HINCKLEY NATIONAL RAIL FREIGHT INTERCHANGE

Project reference TR050007

Applicant's Response to Deadline 4 Submissions [part 2 - HBBC]

Applicant's Response to HBBC Deadline 4 Submission - Response to Additional Deadline 3 Submissions

Note: To be read in conjunction with the Access and Rights of Way Plans (document reference: APP-017 to APP-020) and the Public Right of Way Appraisal and Strategy (document reference: 6.2.11.2)

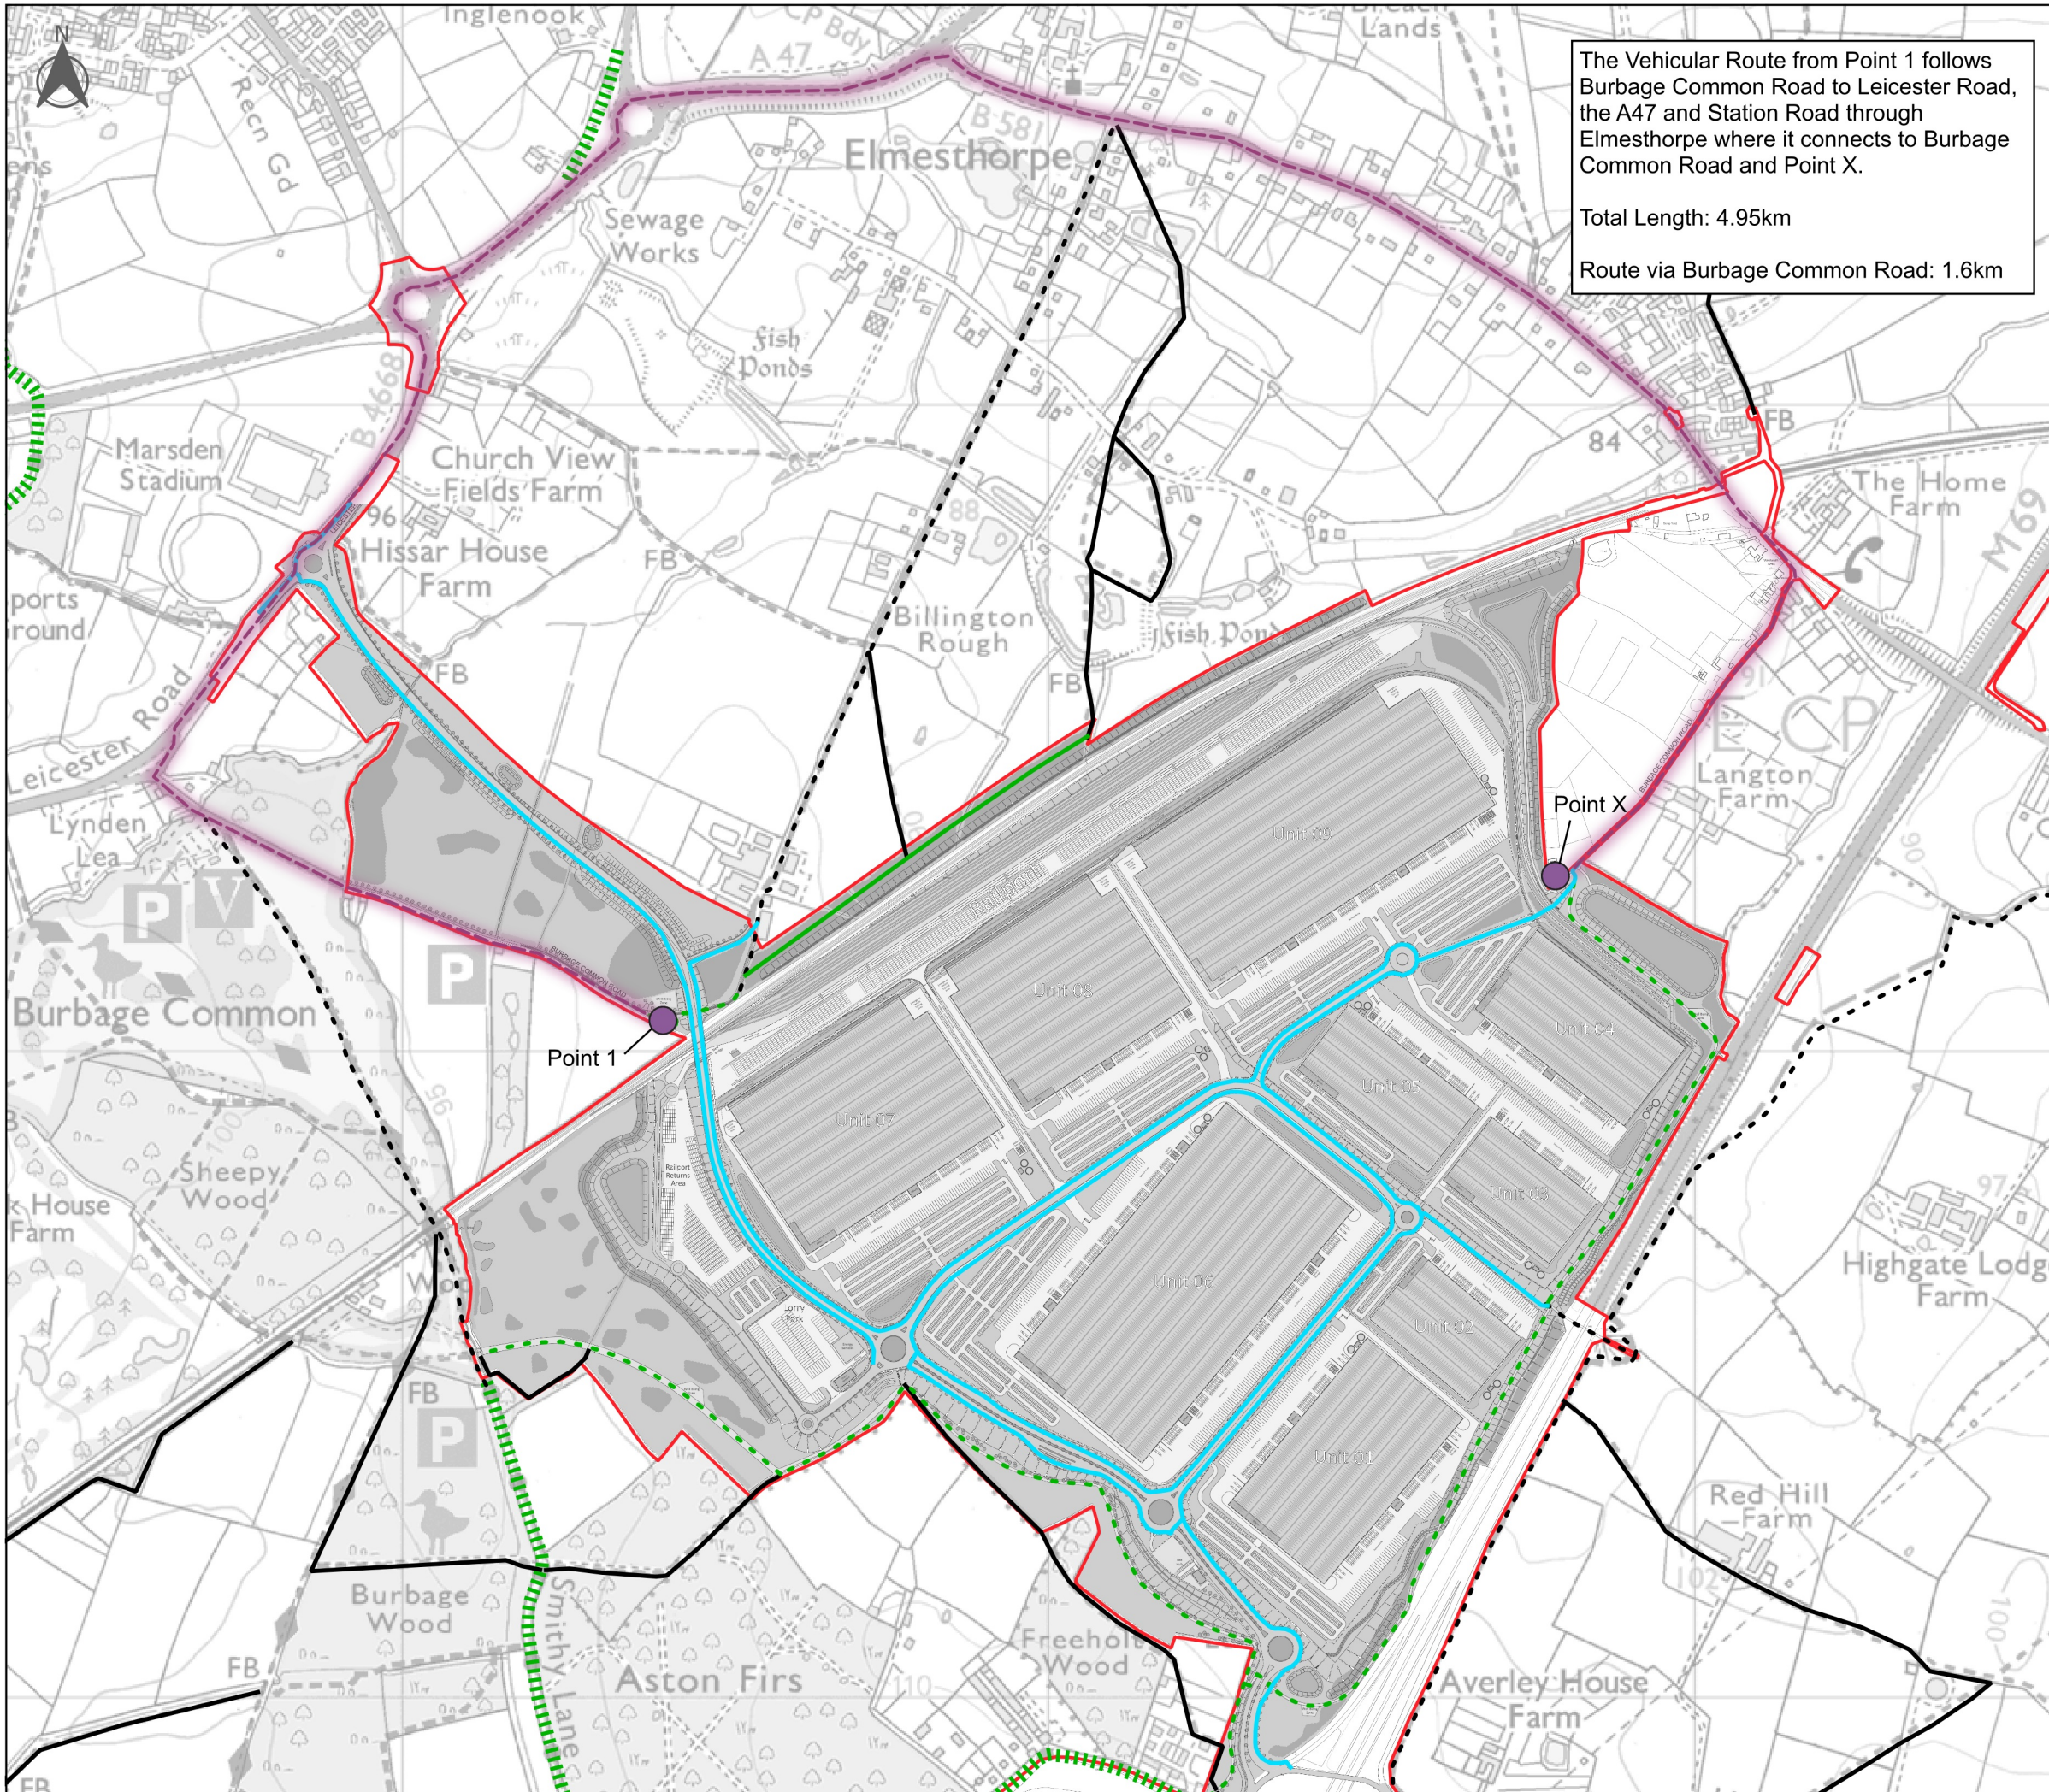
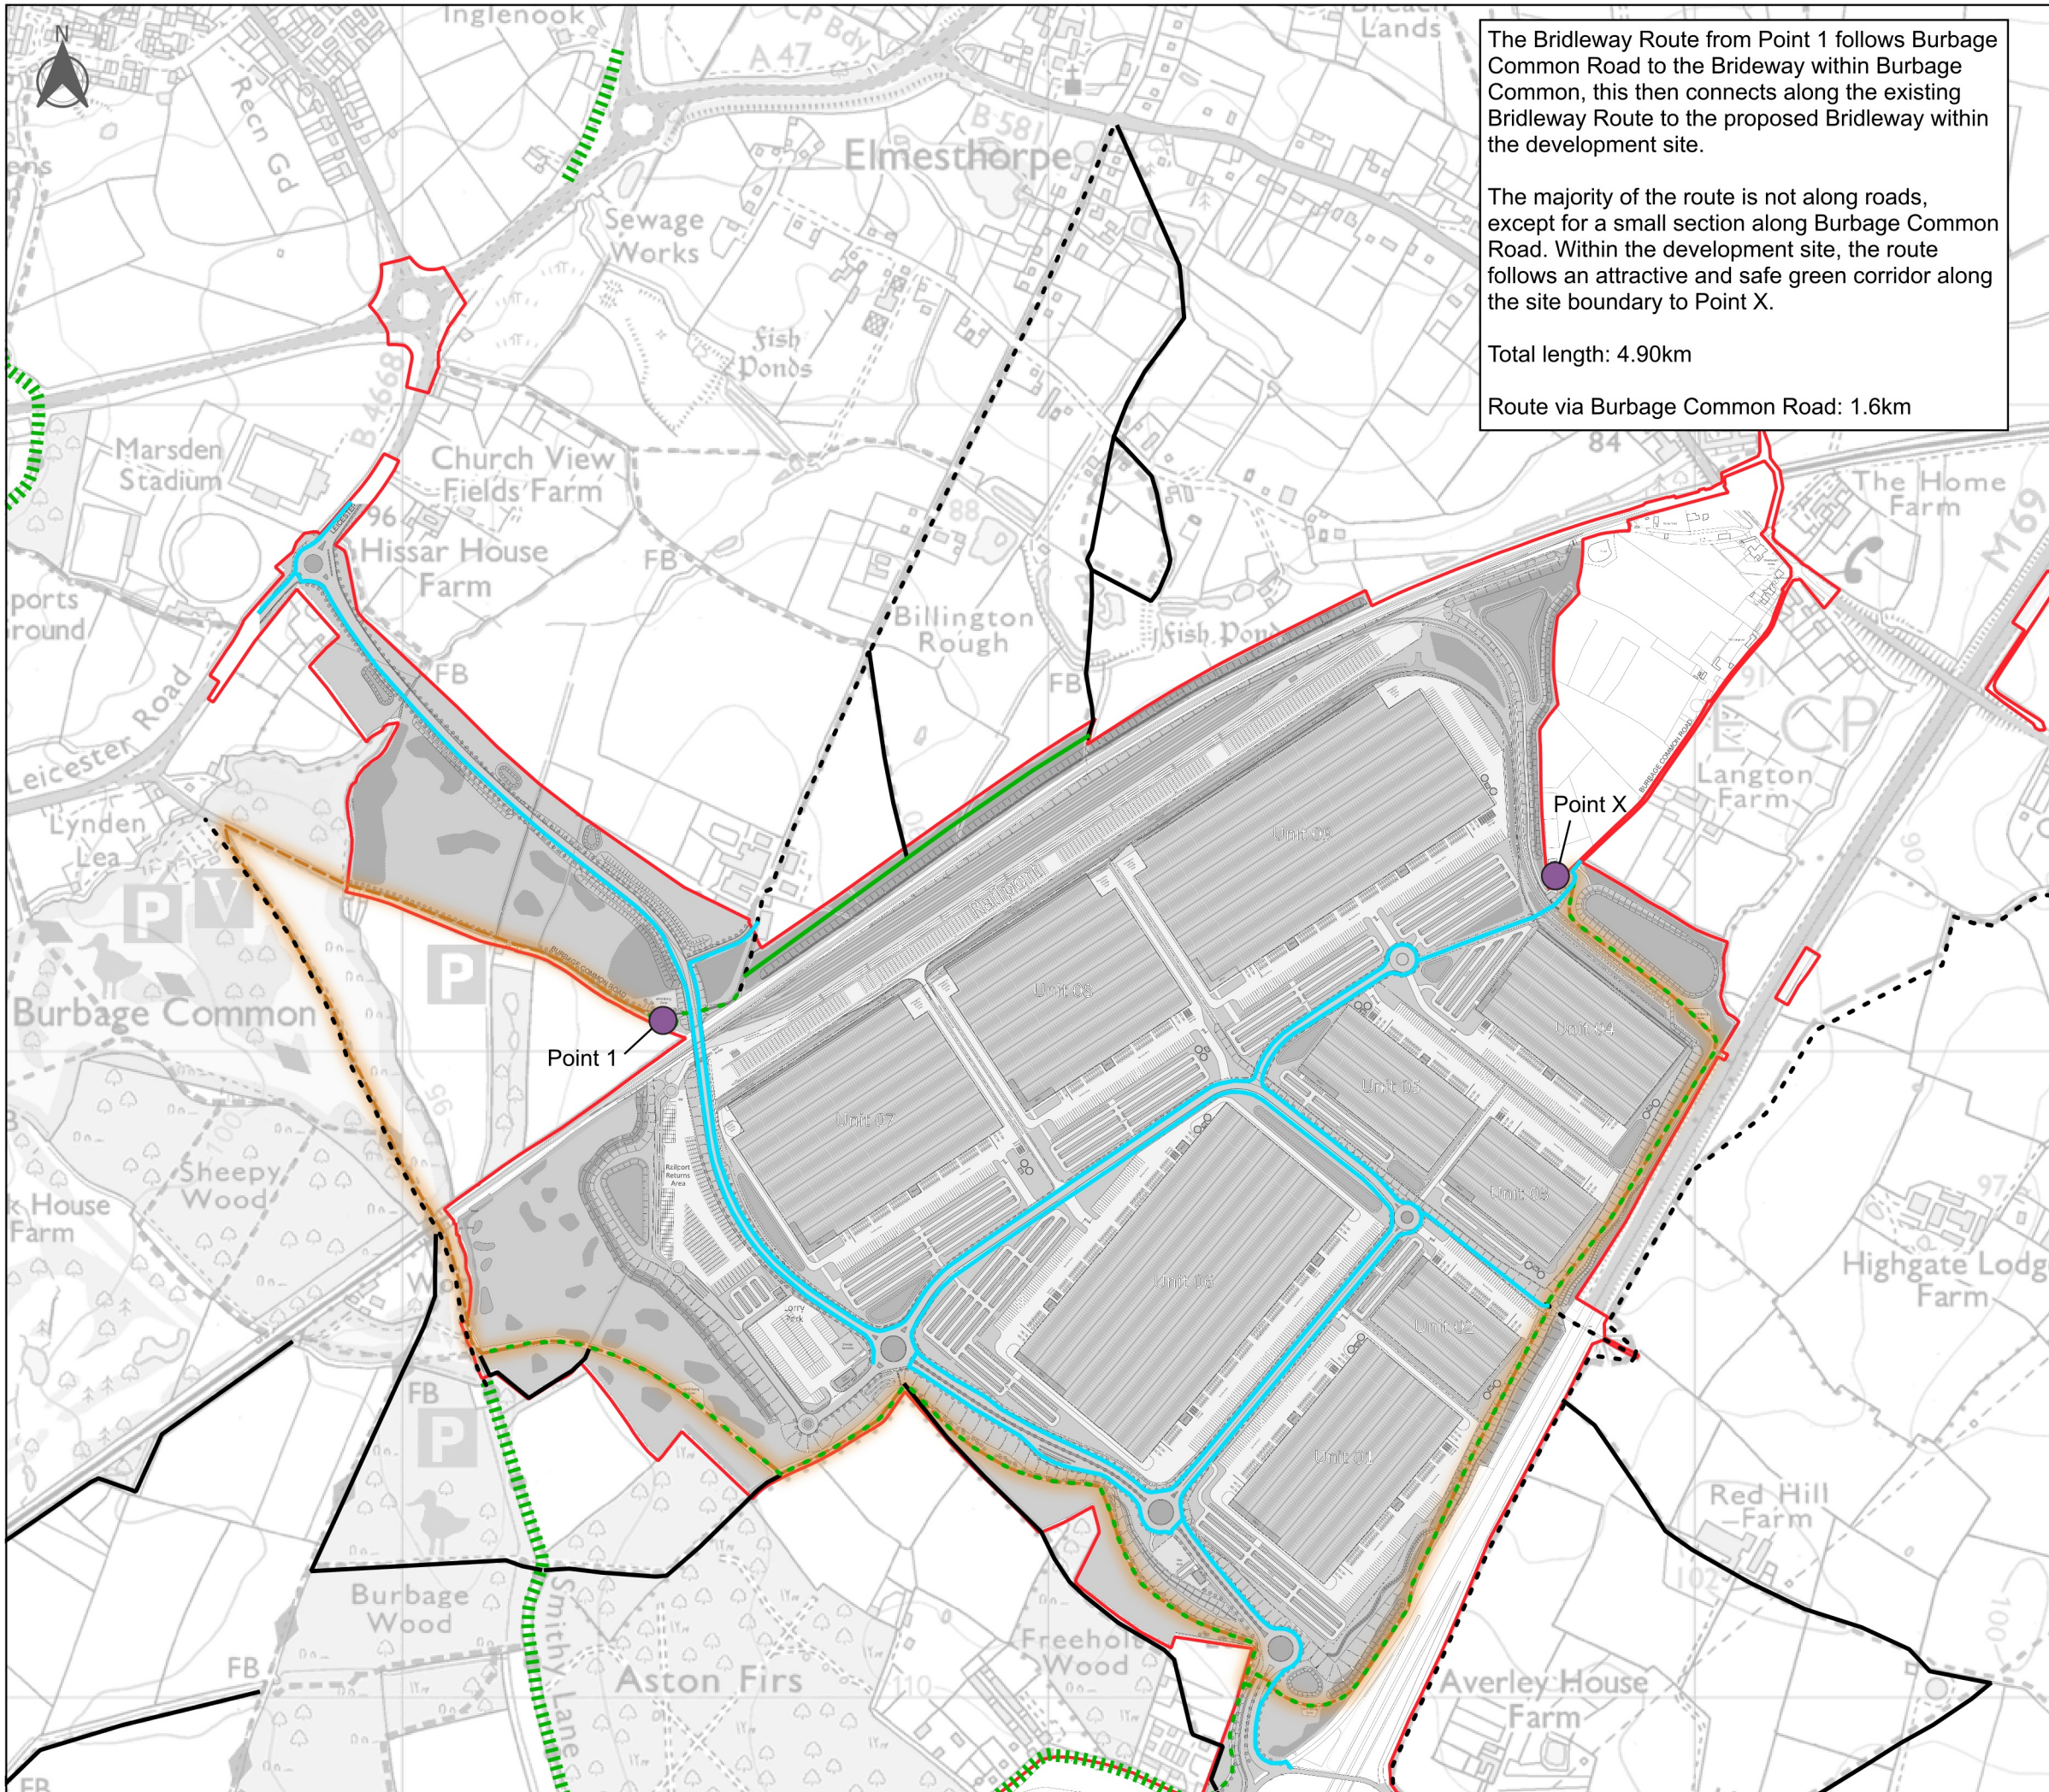
8	REP3 – 054 – Accessibility	The accessibility plans for walking and cycling appear incorrect and thus confusing. For example	Figure 11.14A has been updated for Deadline 5 to clarify the position in relation to permissive paths and

No	ExQ Ref	Hinckley & Bosworth Council Response	Applicant's Response
	Plans for Burbage Common Road	they show a 'proposed permissive path' for walkers and cyclists along the A47 – but the Council would expect these to be part of the publicly adopted highway and thus, not permissive paths. The council has expressed concern at details of these routes including the need to cross the link road in path continuity and how safe and what quality the permissive paths will be across the site as well as crossing facilities - these concerns remain.	adopted paths. A plan showing the footpath / cycleway A47 link road design including crossing points is submitted as Written Statement of Oral Case ISH6 (Appendix C – Plan for A47 link road footway / cycleway design (document reference 18.15.3).
	REP3 – 018 – Framework Travel Plan		Written Statement of Oral Case ISH6 [Appendix C - Plan for A47 link road footway/cycleway design]
